WEST SUSSEX COUNTY COUNCIL CONSULTATION

TO:	Arun District Council FAO: Maria Tomalova
FROM:	WSCC - Highways Authority
DATE:	8 April 2021
LOCATION:	Plum Pudding Barn Hoe Lane Flansham PO22 8NS
SUBJECT:	Y/33/21/PL Conversion of existing barn to 1 No. residential dwelling with associated parking (resubmission following Y/137/20/PL). This site is in CIL Zone 3 & is CIL Liable as new dwelling.
DATE OF SITE VISIT:	n/a
RECOMMENDATION:	Advice
S106 CONTRIBUTION TOTAL:	n/a

Drawing Title:
PROPOSED BLOCK PLAN

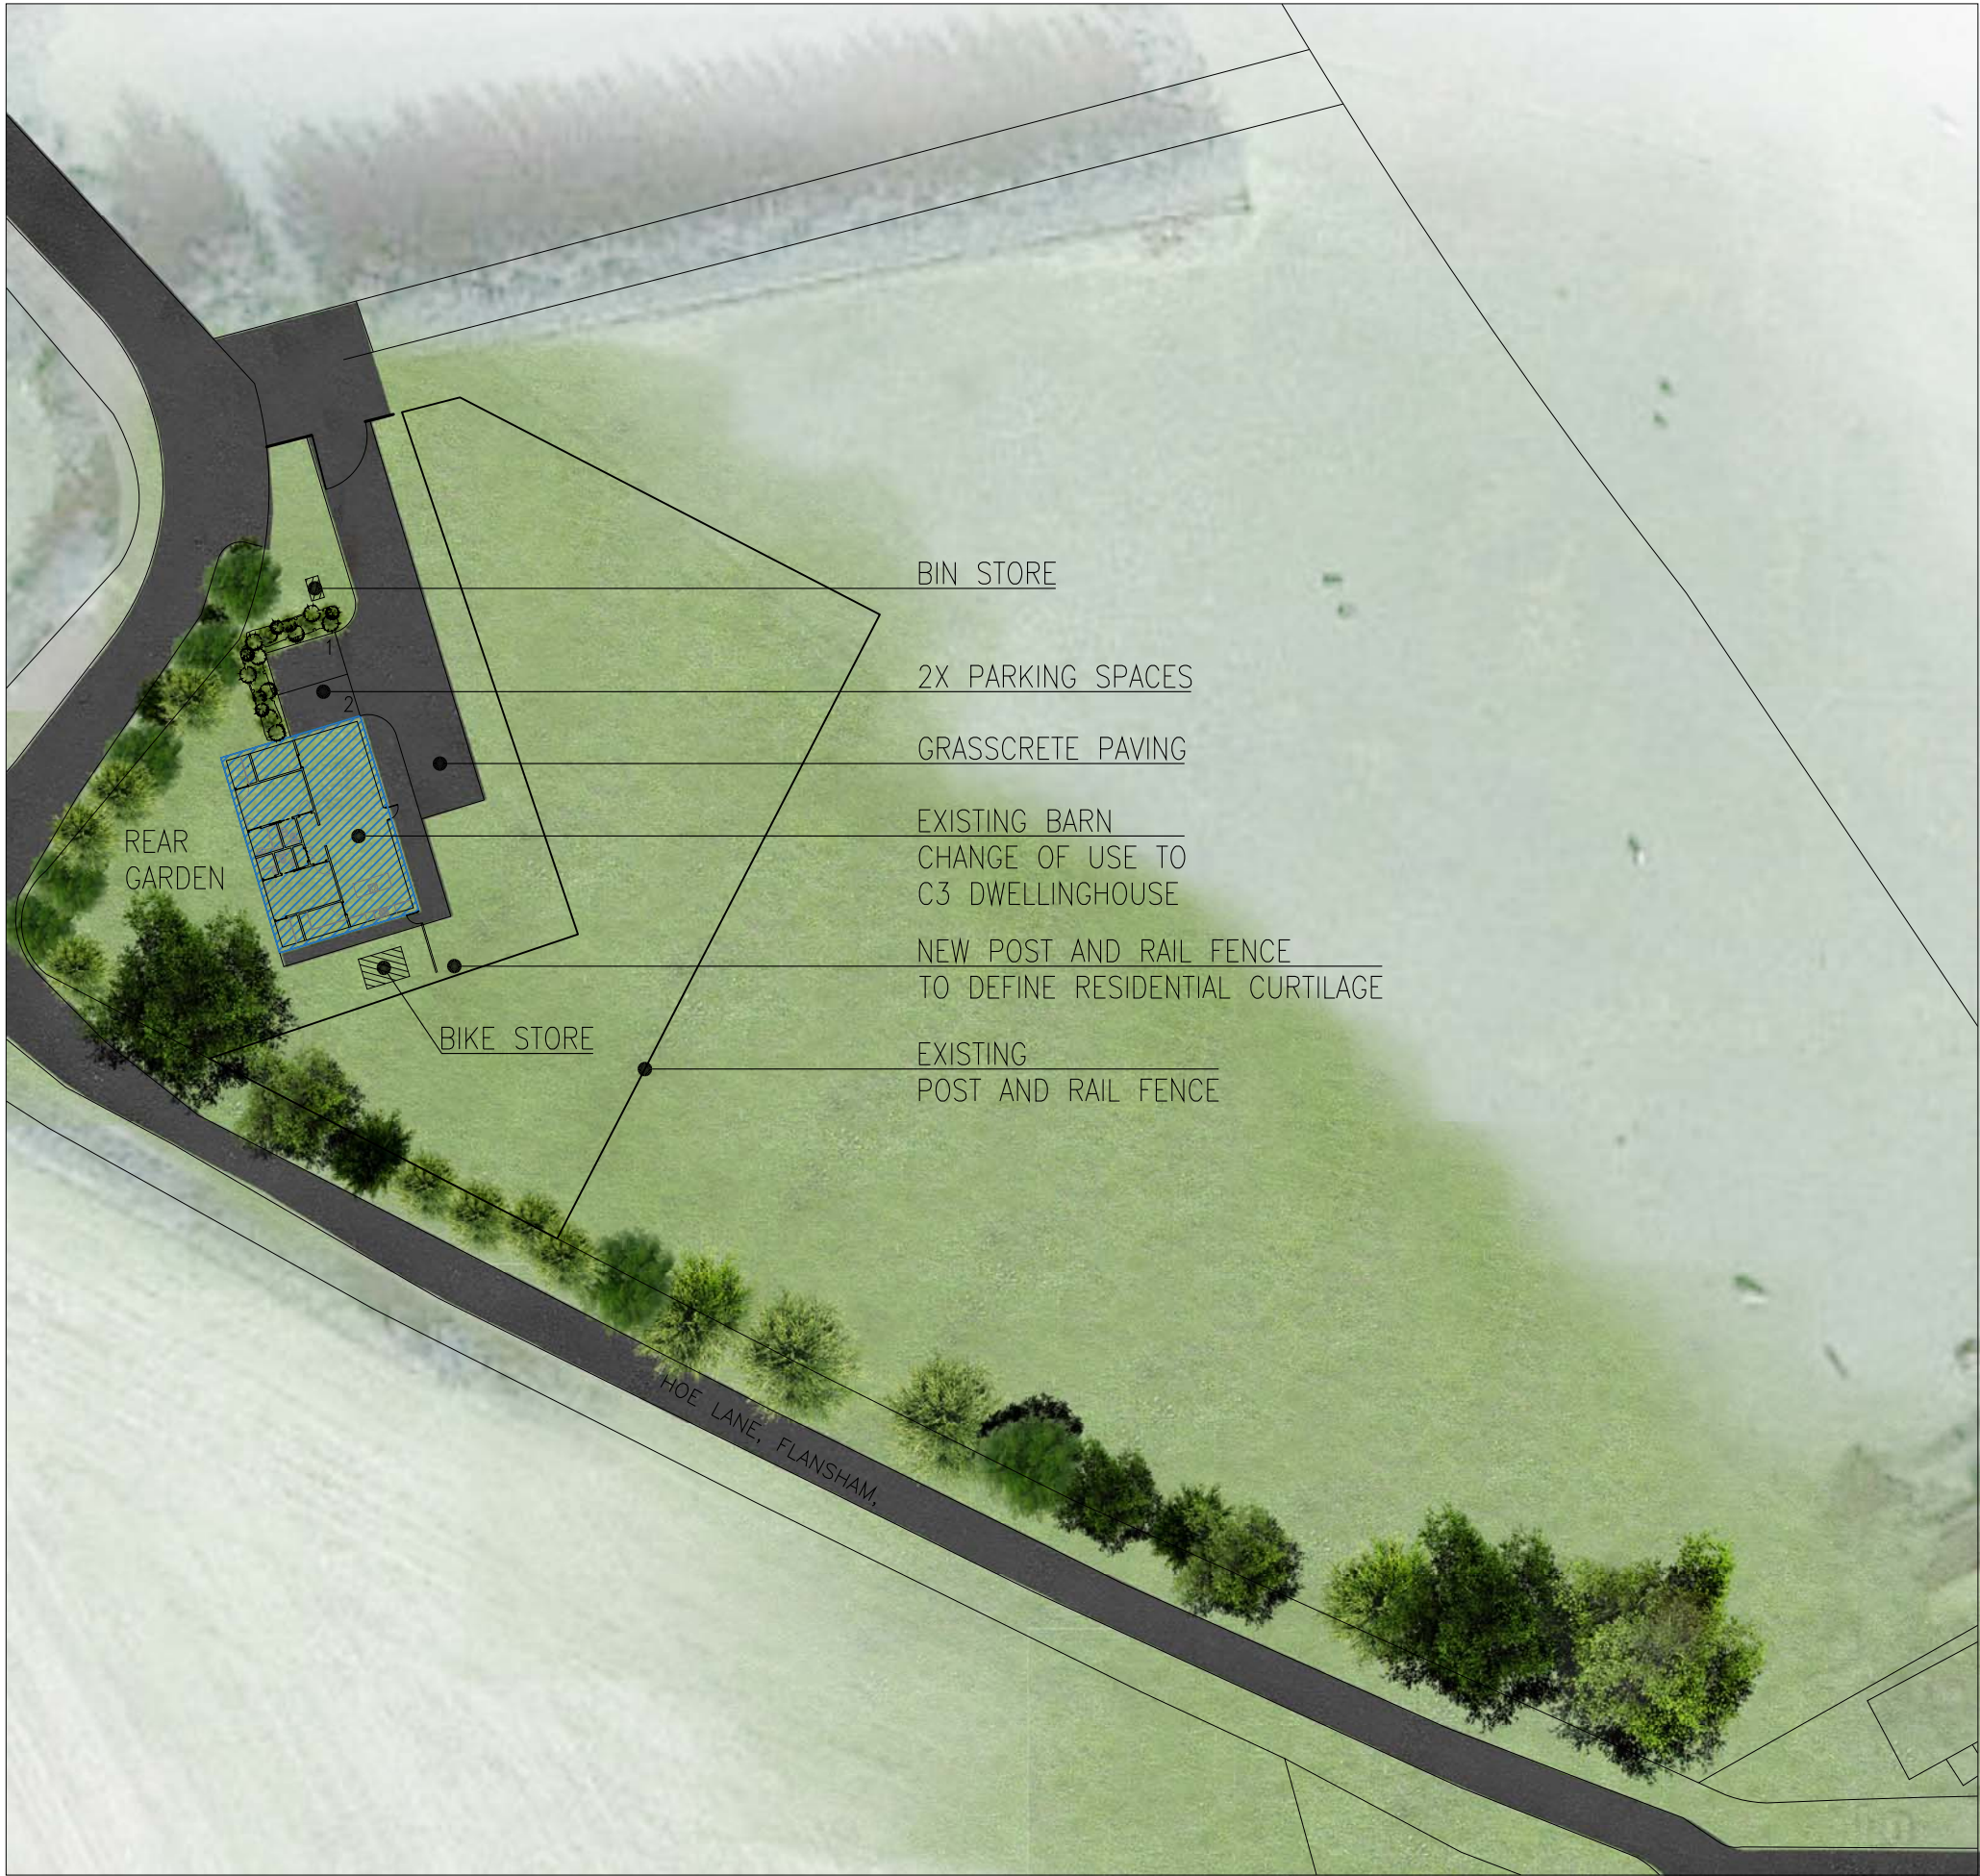
The applicant has provided 2 parking spaces as per required by the Arun parking calculator requires. Though any parking displacement would be considered an amenity issue due to the site being located a distance from any maintained highway.

No part of the development shall be first occupied until the car parking has been constructed in accordance with the approved site plan. These spaces shall always thereafter be kept for their designated purpose.

Drawing Title:
BIKE STORE

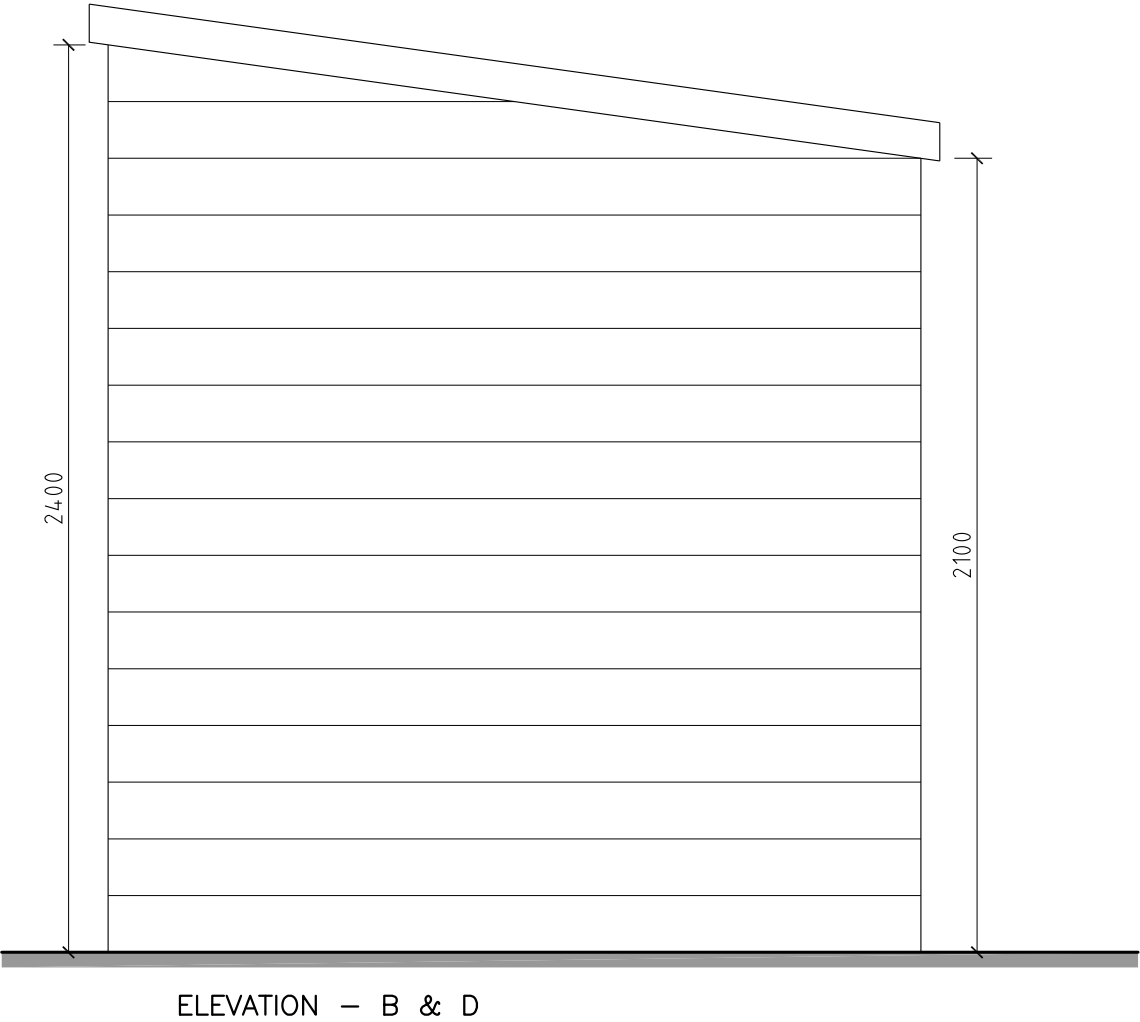
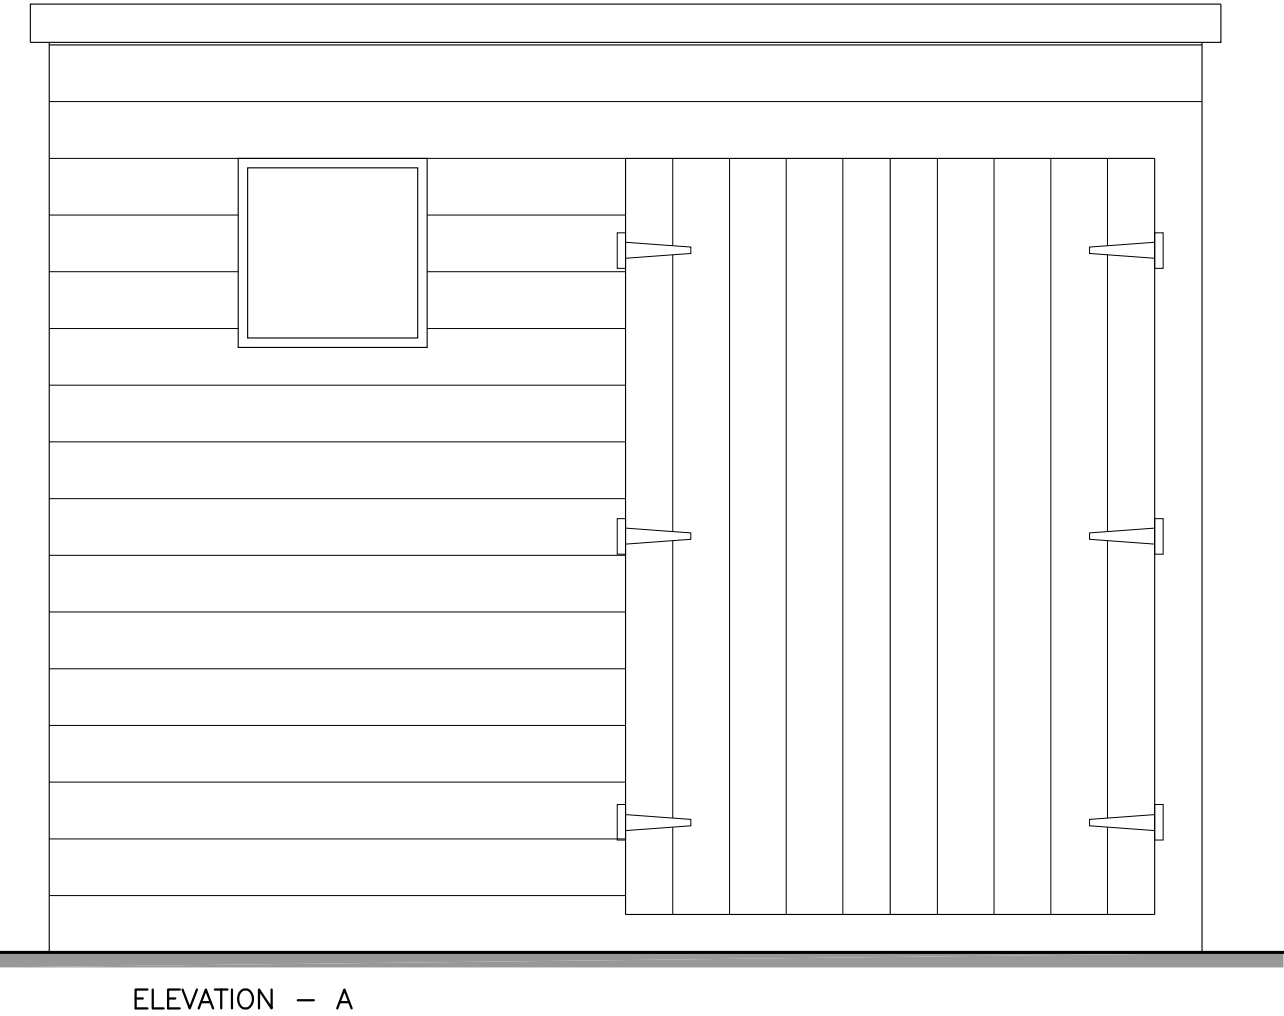
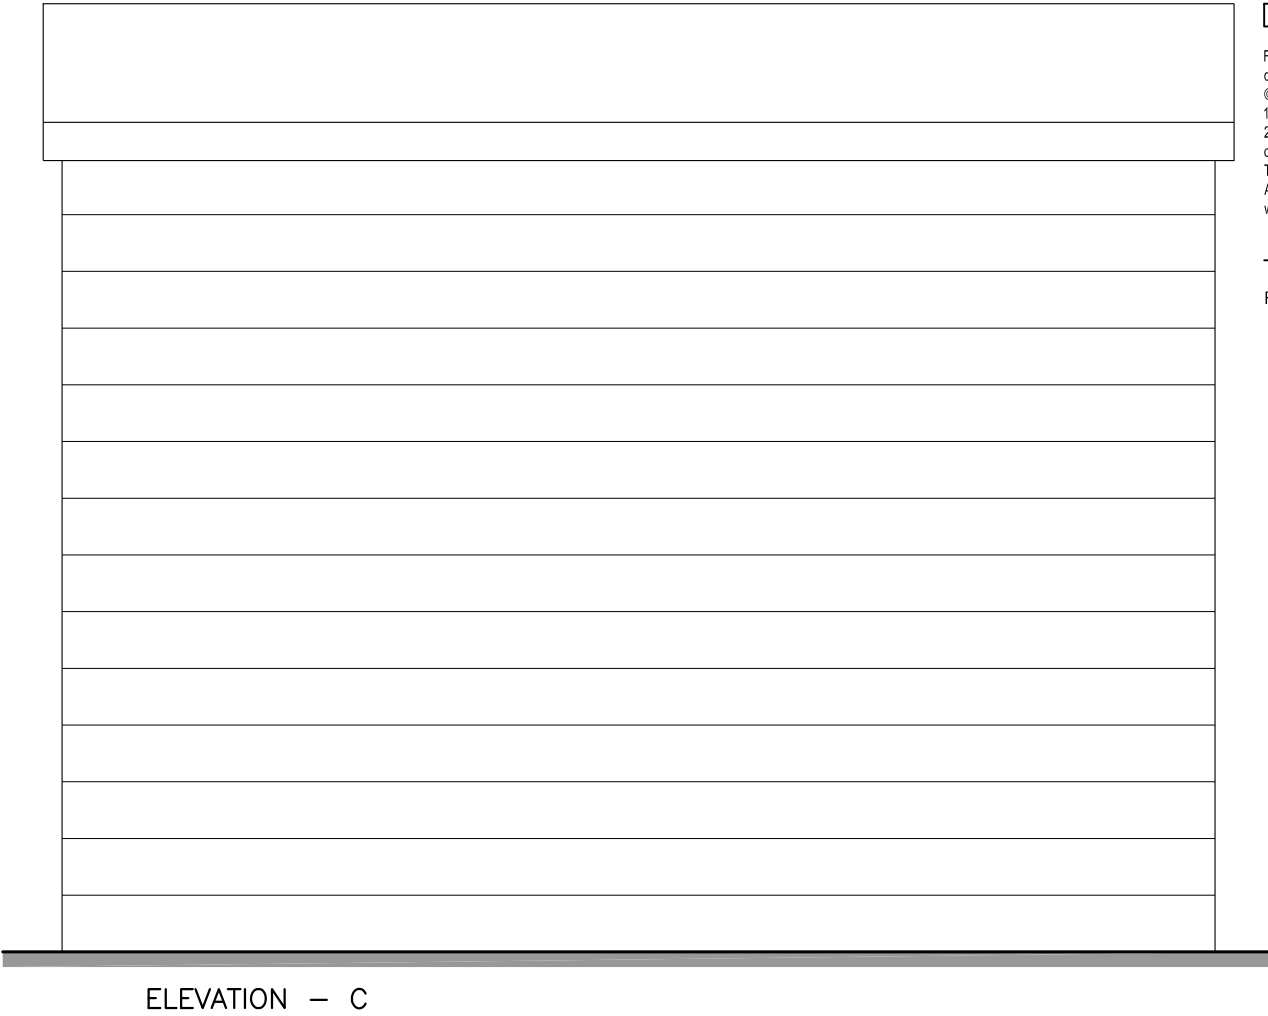
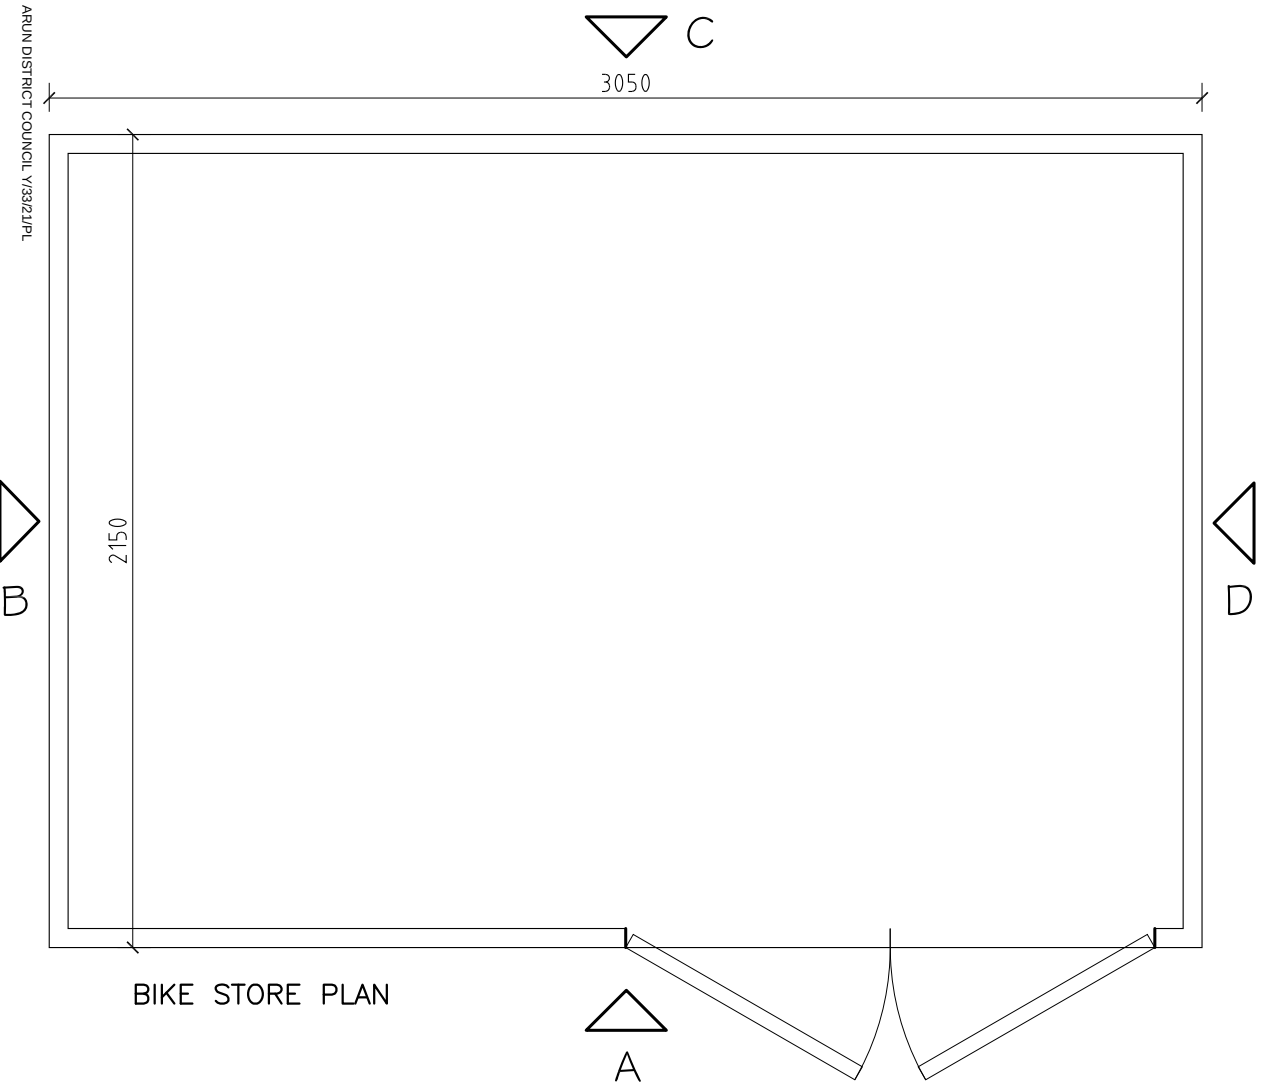
Cycle Parking is to be provided to Manual for Streets (MfS) guidance.

No part of the development shall be first occupied until covered and secure cycle parking spaces have been provided in accordance with the approved site plan.
